Your Ref: OWPC25867
Our Ref: PO/1/20/HH 21-01-2020
Please ask for:
Zac Denton

Retention of car port to side elevation & raised roof to existing garage.

9 Arundel Road Poling

Proposed Ground Floor

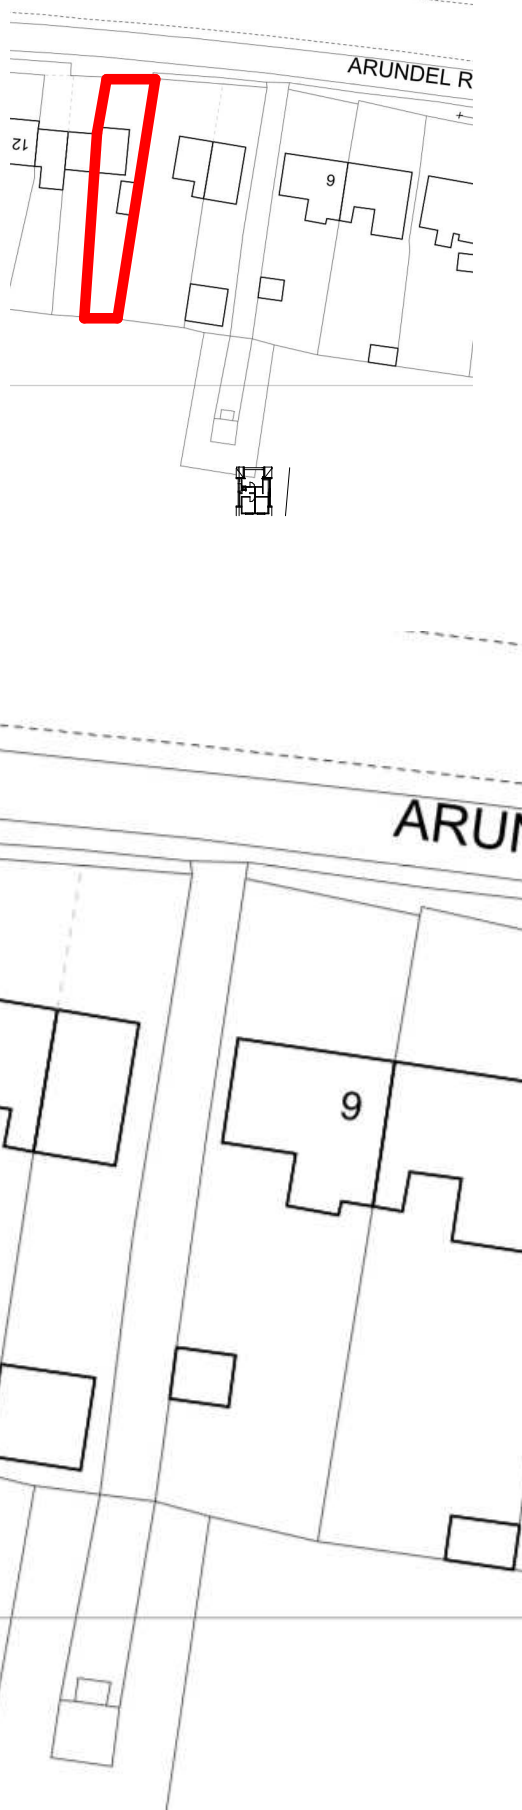
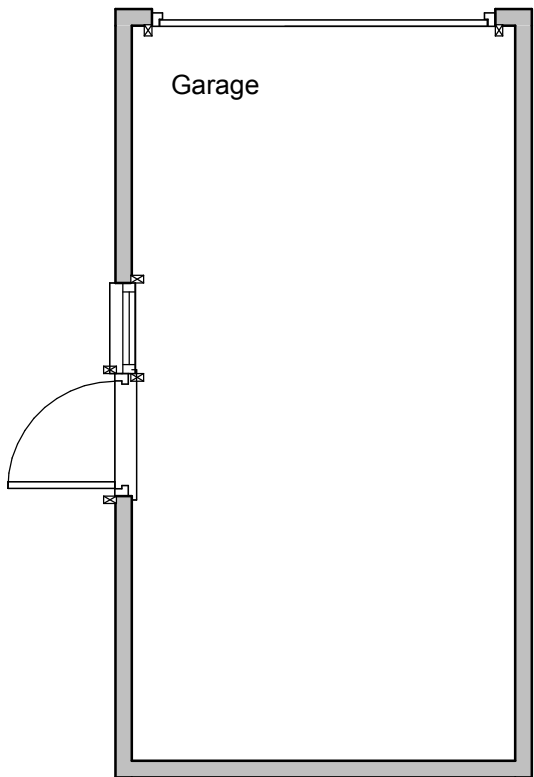
the proposed carport will be over the access for my house No.10, as a council tenant this will make it very difficult for the council to effect any repairs or work to be done to the rear of the property and also make it impossible for me to access with anything long such as a ladder or wheelbarrow etc, this access will be shown on both the deeds of No.9 and No.10 and is already not respected by No.9 and i feel sure that in the future would be even further obstructed by the construction of the proposed building both by the vehicles that would be placed in it and the pillars and roof reducing the access even further, also i would be glad to receive information as to the definition to the nature of the access because as it stands at the moment there is not even enough access to move a wheelie bin through for my recycling, thank you
